**Consultation Response from KC, Highways Development Management (HDM)**

**2023/91491 Prickleden Mills, Woodhead Road, Holmfirth, HD9 2JU**

**Date Responded: 28/07/23**

**Responding Ref: K3-36/23**

PROPOSED SITE PLAN

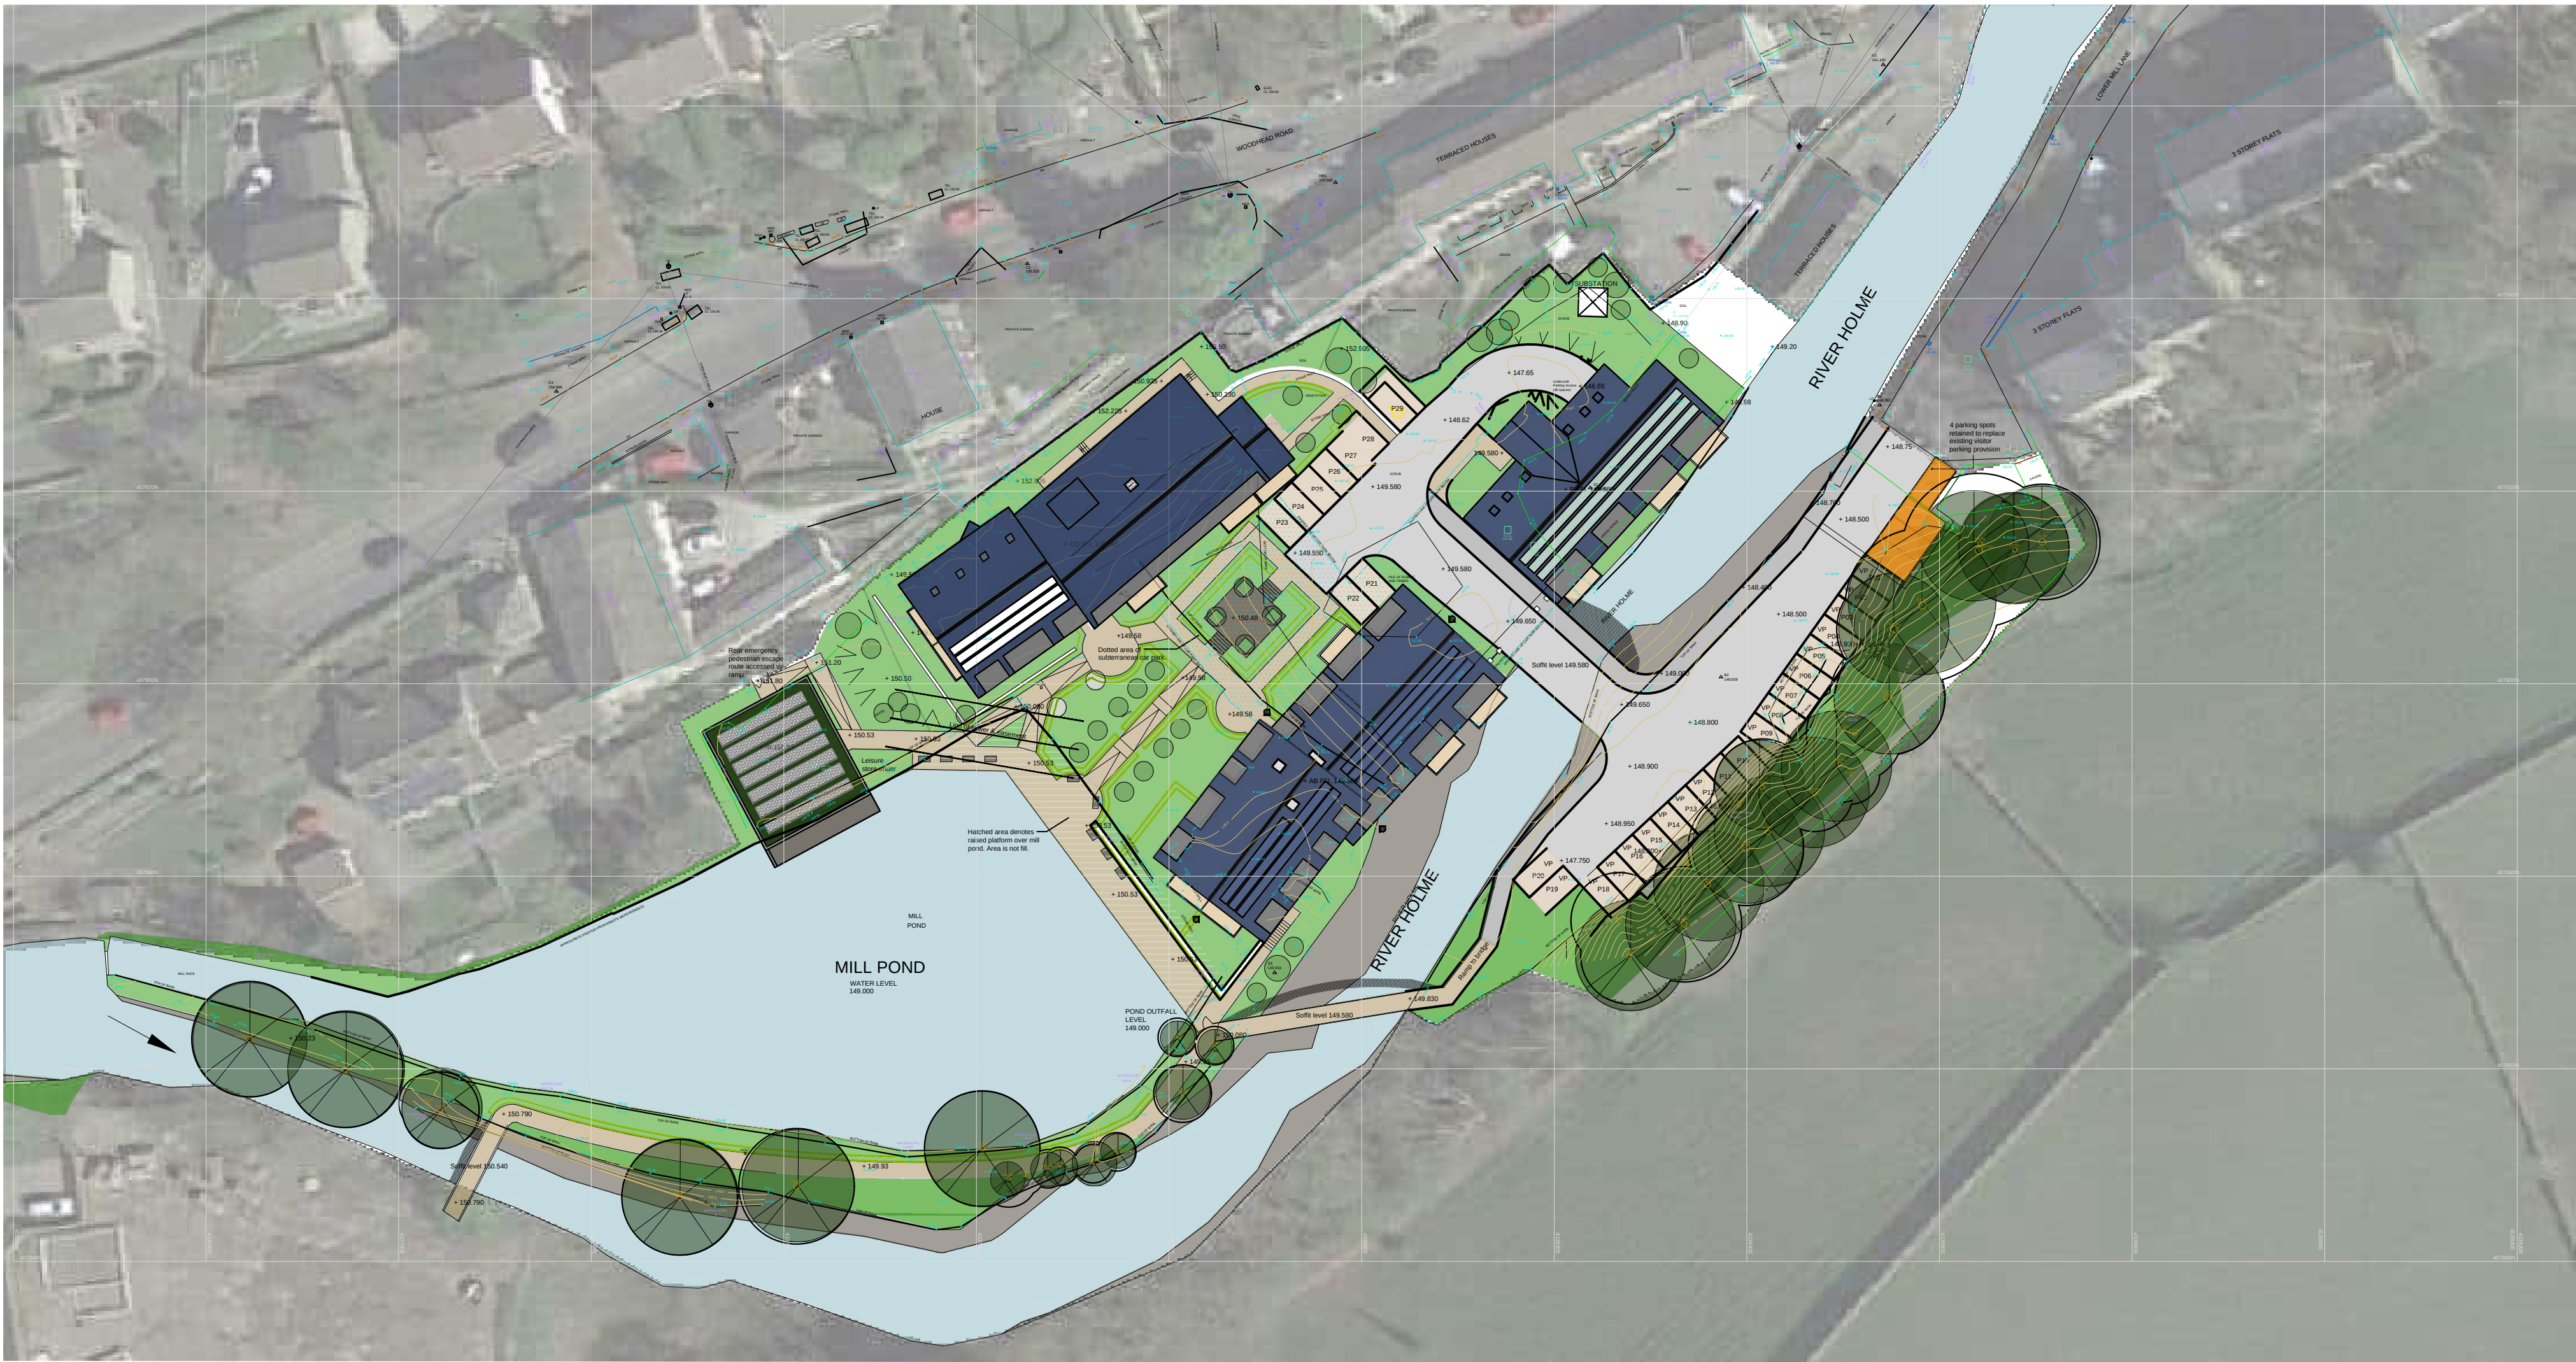
- It is envisaged that the highway boundary is proposed to be amended to include the relocated visitor parking bays and not the remainder of the site access roads. However, this should be clarified on detailed highway works plan, with the highway boundary clearly delineated in the design. A transition ramp at the highway boundary may also be beneficial, which would help delineate the highway boundary and ensure slow speeds to/from the site.

- 0.6m wide margins are required to the rear of the relocated public visitor parking spaces and included in the highway boundary. A 0.6m margin should also be provided to the side of the last public parking bay, which will help to delineate these spaces from the private on-site parking.

- Amendments to the boundary fencing adjacent to the visitor parking will be required, as well as new/amended street lighting.
- The parking aisle width must be a minimum of 6m adjacent to all parking bays to allow for manoeuvring to/from bays. No waiting restrictions (Double Yellow Lines) will also be required opposite the visitor parking bays, with the necessary TRO changes clearly annotated on the proposal plans.

- A min. 2m wide footway is required along the Riverside Walk route (the current proposals do not appear to provide this in some places). Safety fencing is also required adjacent to the river, which is of appropriate design for the conservation area setting.

- There are a number of what appear to be columns in the basement car park that would affect safe turning to/from the bays. Therefore, this needs to be clarified, with the columns relocated where necessary (subject to swept path analysis).

- It is also noted that if these are columns in the basement, they also appear to impact on the use of the proposed disabled/accessible parking bays, with side access being blocked by the columns. Clear 1.2m wide transfer zones are normally required for this purpose, which are missing from the current layout and should be incorporated.

- The parking aisles adjacent to any parking bay must be a minimum of 6m to allow for turning to/from the spaces. This is not available for all spaces, including P19-P22 & P36, and the layout needs to be amended accordingly.

- At the end of parking aisles, it is usual to extend the aisle beyond the last space to enable ease of access. This has not been provided for the basement and surface car parks. Therefore, this should be incorporated, or swept path analysis provided to confirm that a large car can access these spaces. Alternatively, the last bays in the aisle could be widened instead.

- The Riverside Walk route from Lower Mill Lane is not of good quality, with a footway less than 2m wide proposed for the initial section, and a lack of any footway through the parking area adjacent to parking spaces P14-P22. There is also a lack of pedestrian crossing facilities at the link bridge crossing point.

- Access to the footbridge adjacent to parking spaces P22 is noted at being ramped. Whilst no details of the ramp gradient are provided, based on the limited spot level information it appears that the ramp would be in excess of 1:20, which would make it inaccessible for some users.

- The proposed Riverside Walk and footbridges are shown at 1.5-1.8m in width. This should be widened to a minimum of 2m clear width in accordance with DfT document 'Inclusive Mobility'. Consideration should also be given to whether the route could be upgraded for cycle use.
